**Re: Development Application SSD 8373 – Alexandria Park Community School Redevelopment, Park Road, Alexandria 2015**

I am writing to voice my concerns over some elements of the proposed redevelopment of Alexandria Park Community School, Park Road, Alexandria.

SHADOW DIAGRAMS

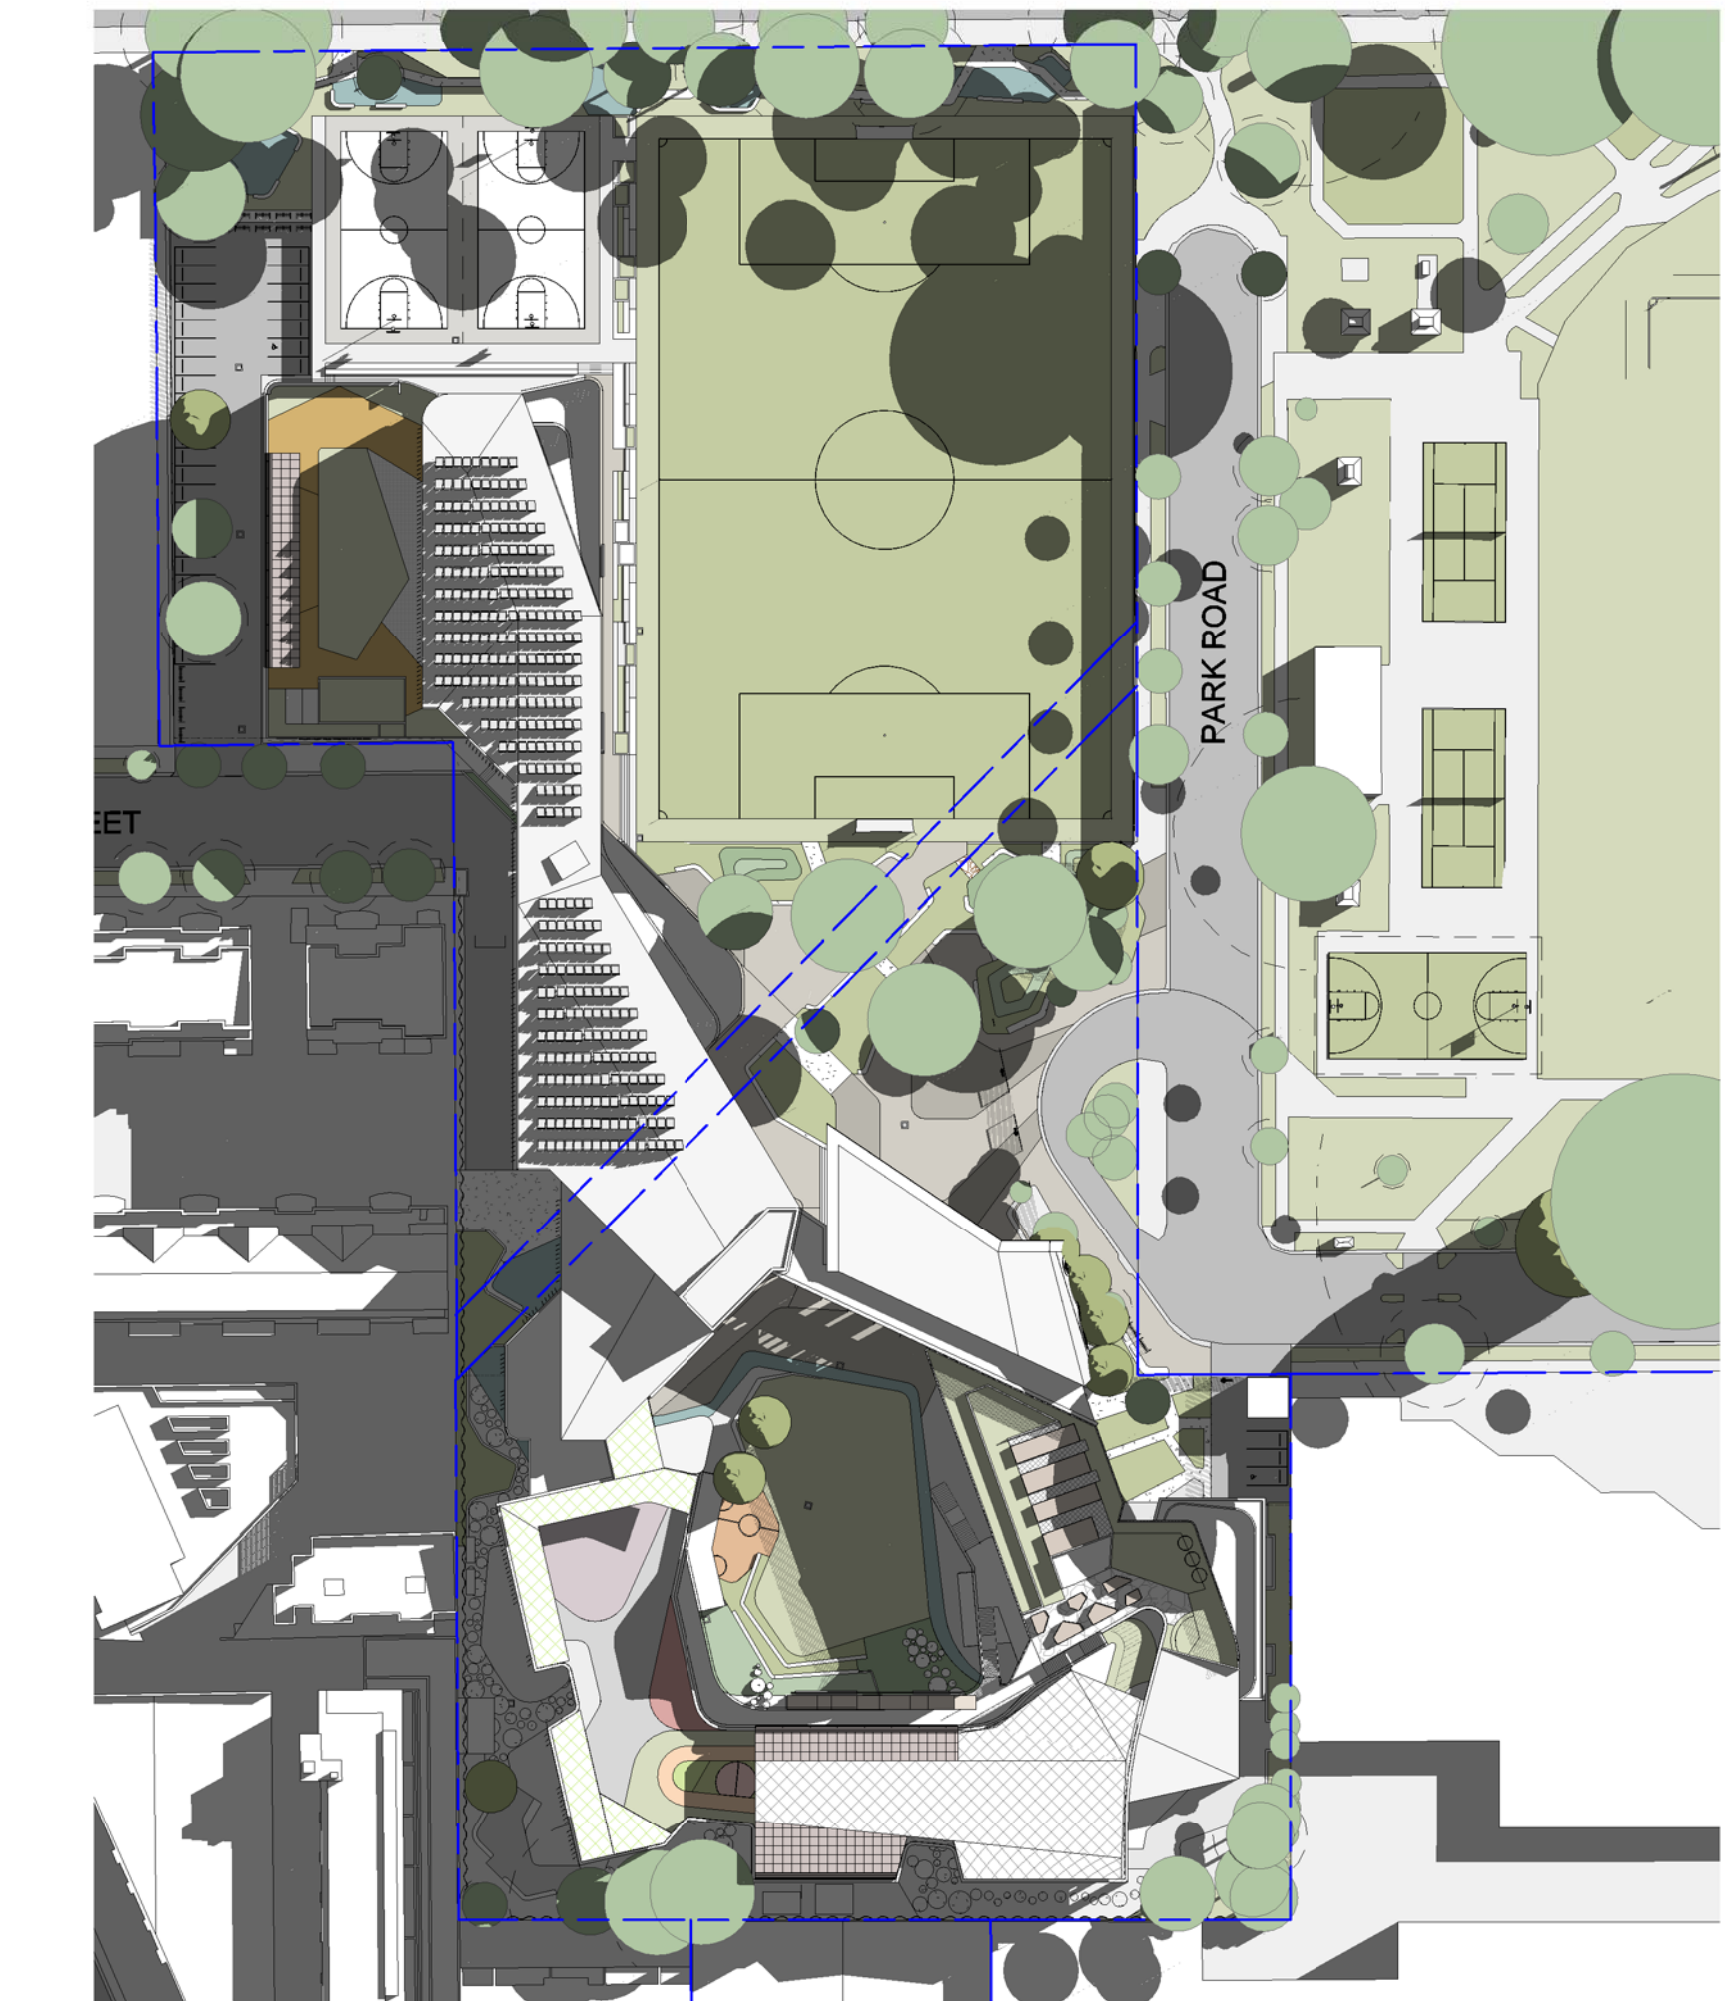
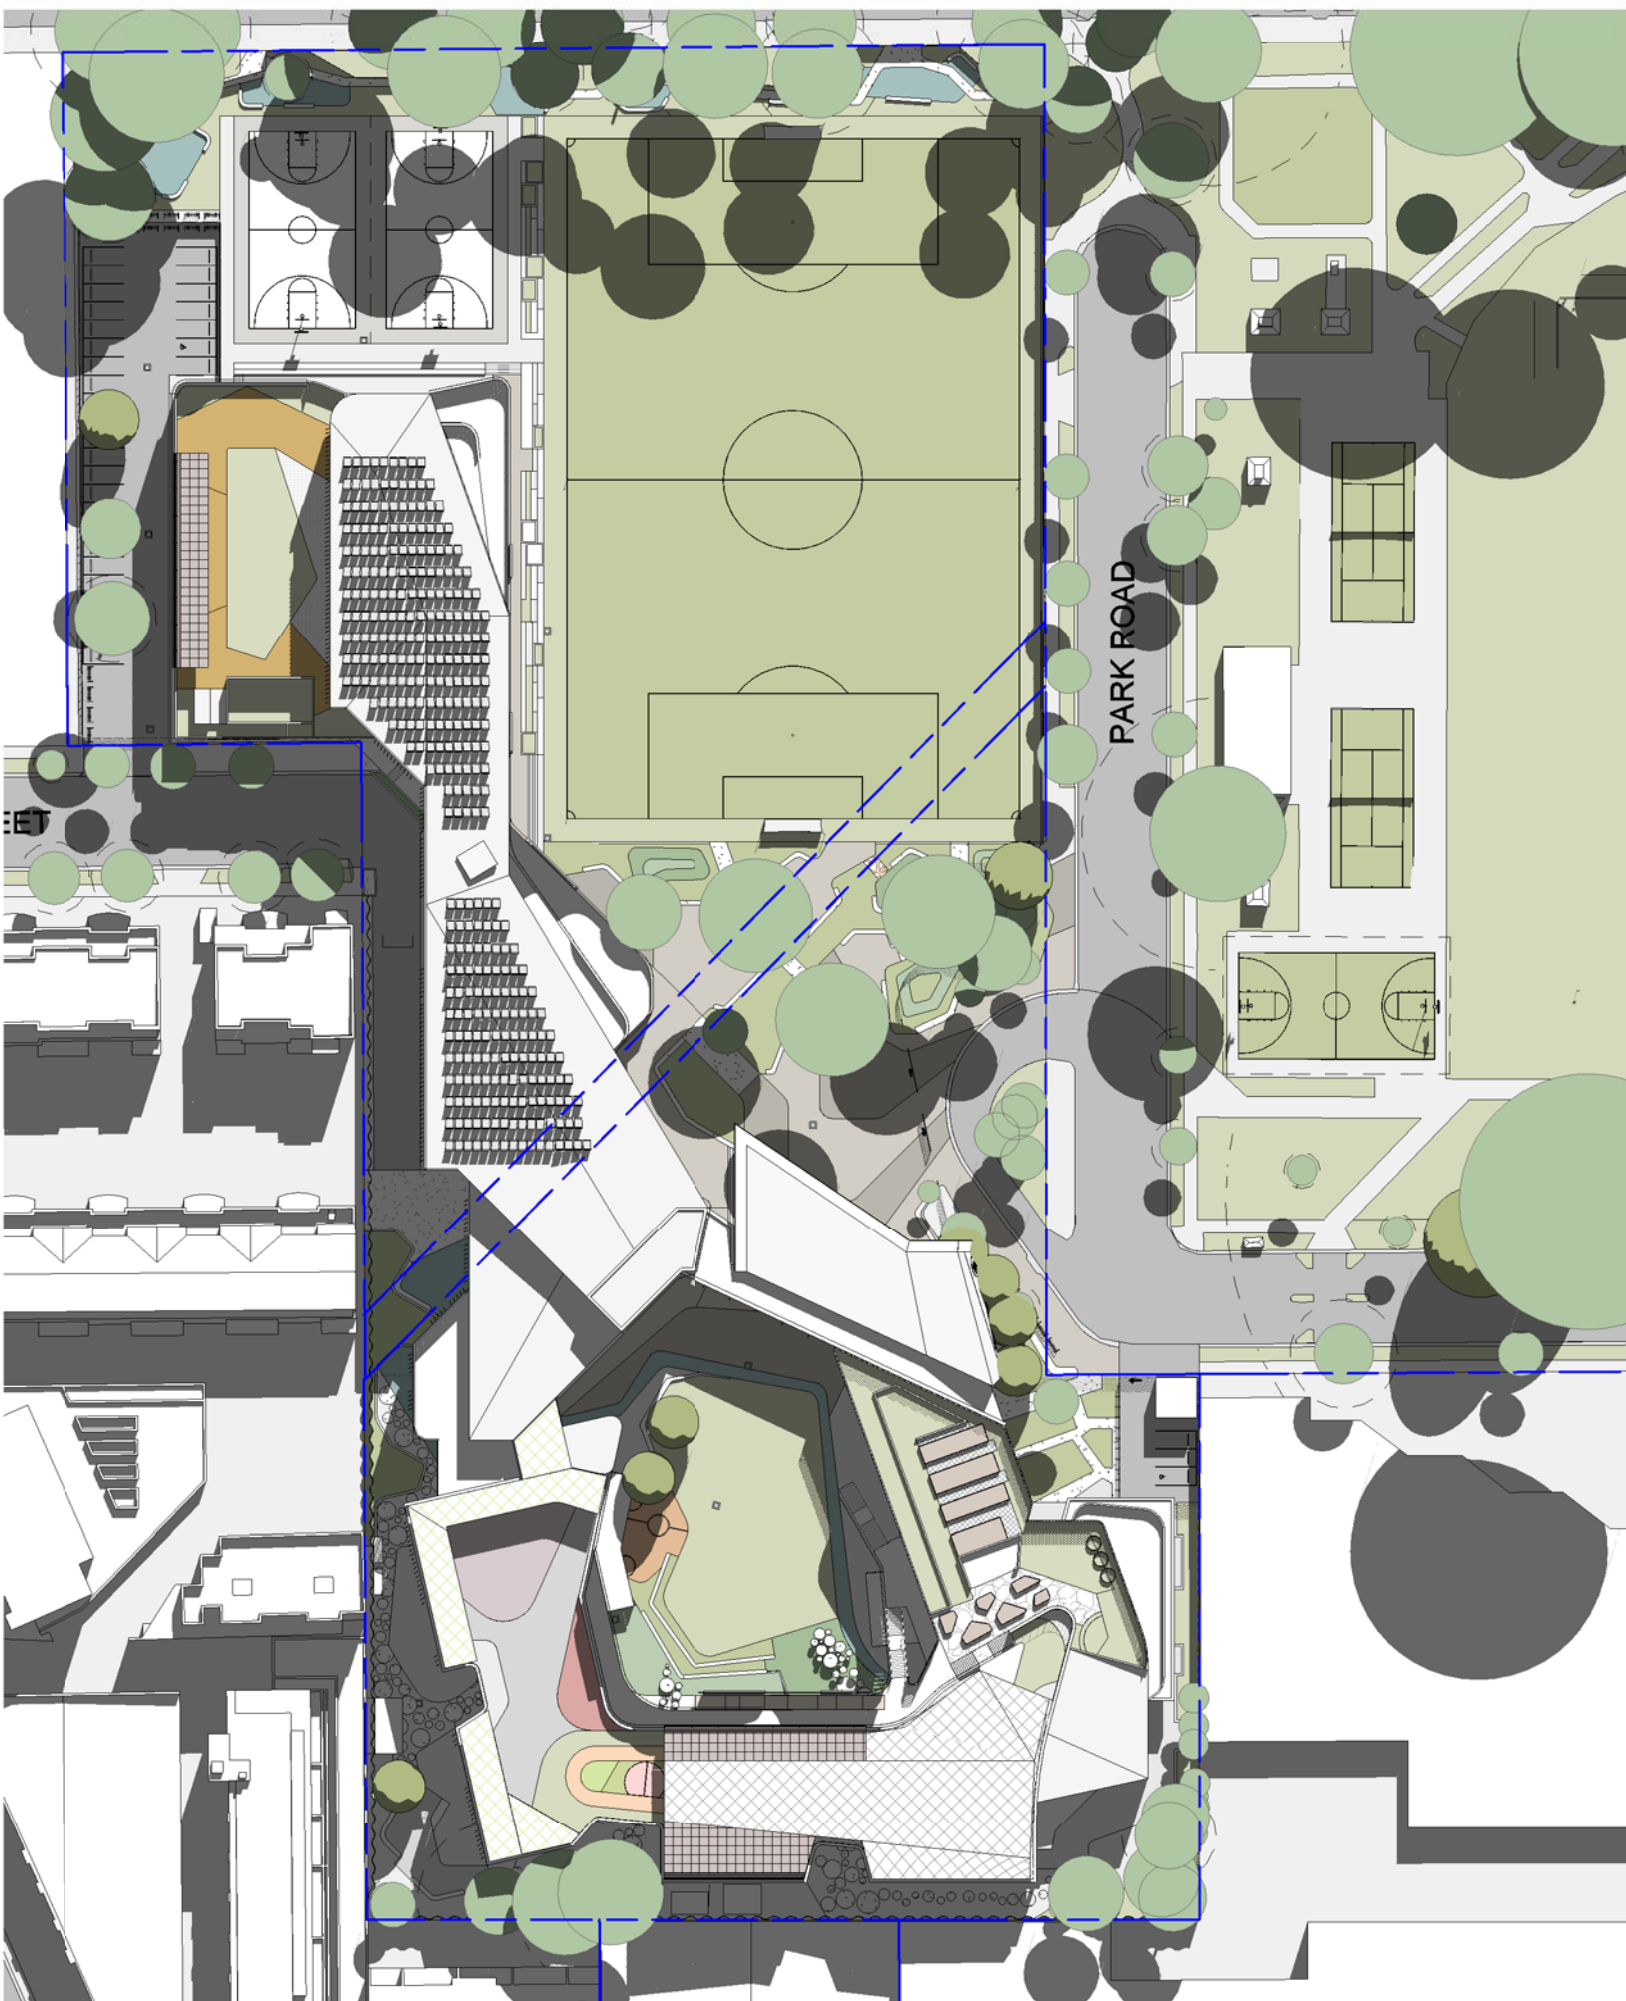
The 15 units in 141-143 McEvoy Street on the southern boundary all have living areas & outdoor areas facing north and the impact on of the overshadowing has not been properly assessed. The documents currently notes the buildings along the south perimeter as commercial which is not correct. There are **no shadow elevational diagrams** at all on Drawing No. AR.DA.5002 P1 for 141-143 McEvoy Street which is a residential property & therefore as my understanding is, is required to be taken into consideration.

The shadow plans show that the southern properties will have all sunlight removed at ground level. Has the lowered level of my property and the 5 adjacent properties been taken into consideration in the assessment?
